H. B. ZACHRY COMPANY REQUEST FOR INFORMATION ADDISON AIRPORT TUNNEL 127B

NORTH TEXAS TOLLWAY AUTHORITY ADDISON AIRPORT TUNNEL

RFI# 112 - 127B

CONTRACT No. DNT-260 SHEET E157 OF 166

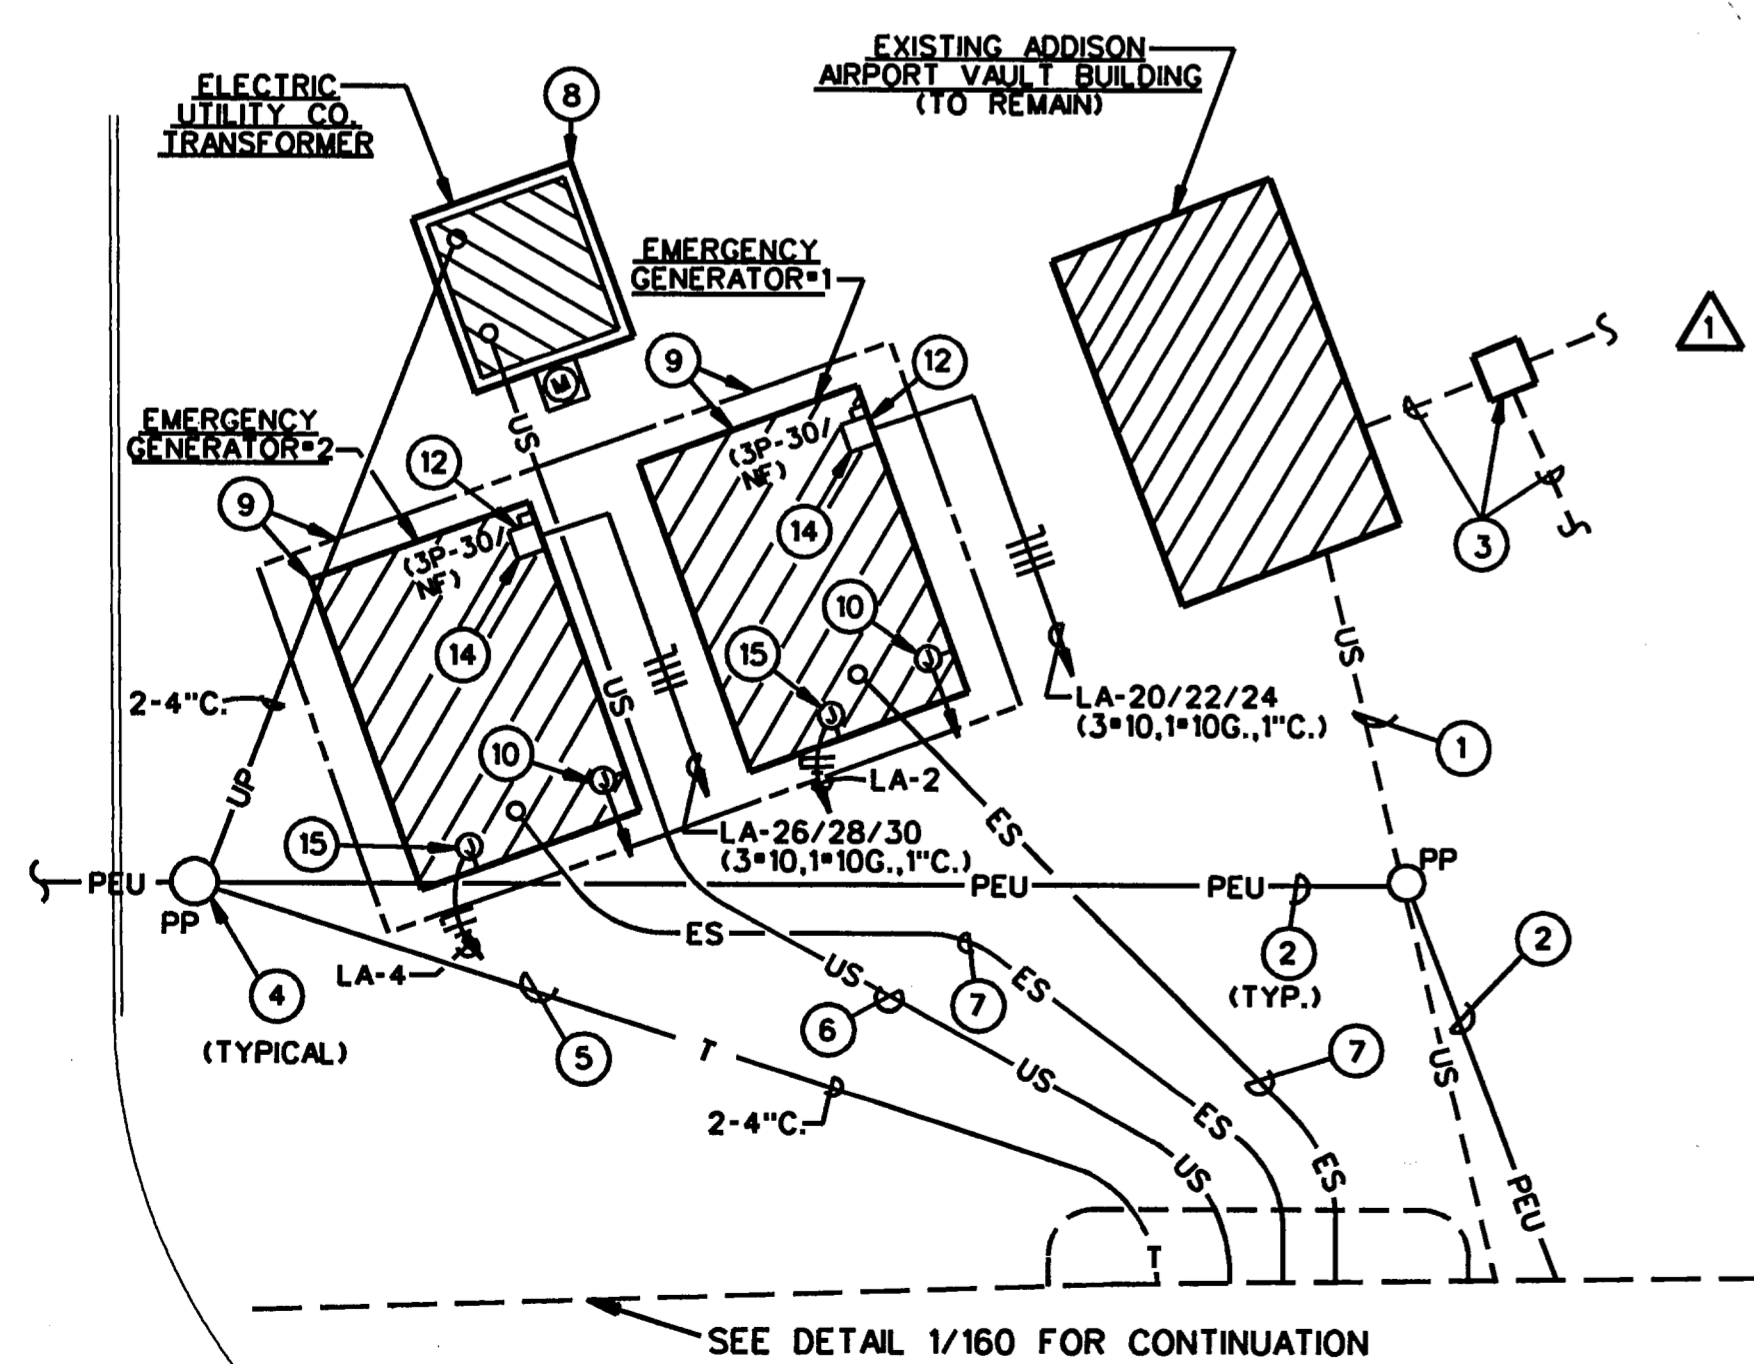
Problem: Attached is a sketch (not to scale) which shows a new power pole (#2) in conflict with Emergency Generator Pad #1.

Response by Construction Management: The contractor's solution would require the contractor to relocate the generator pad.
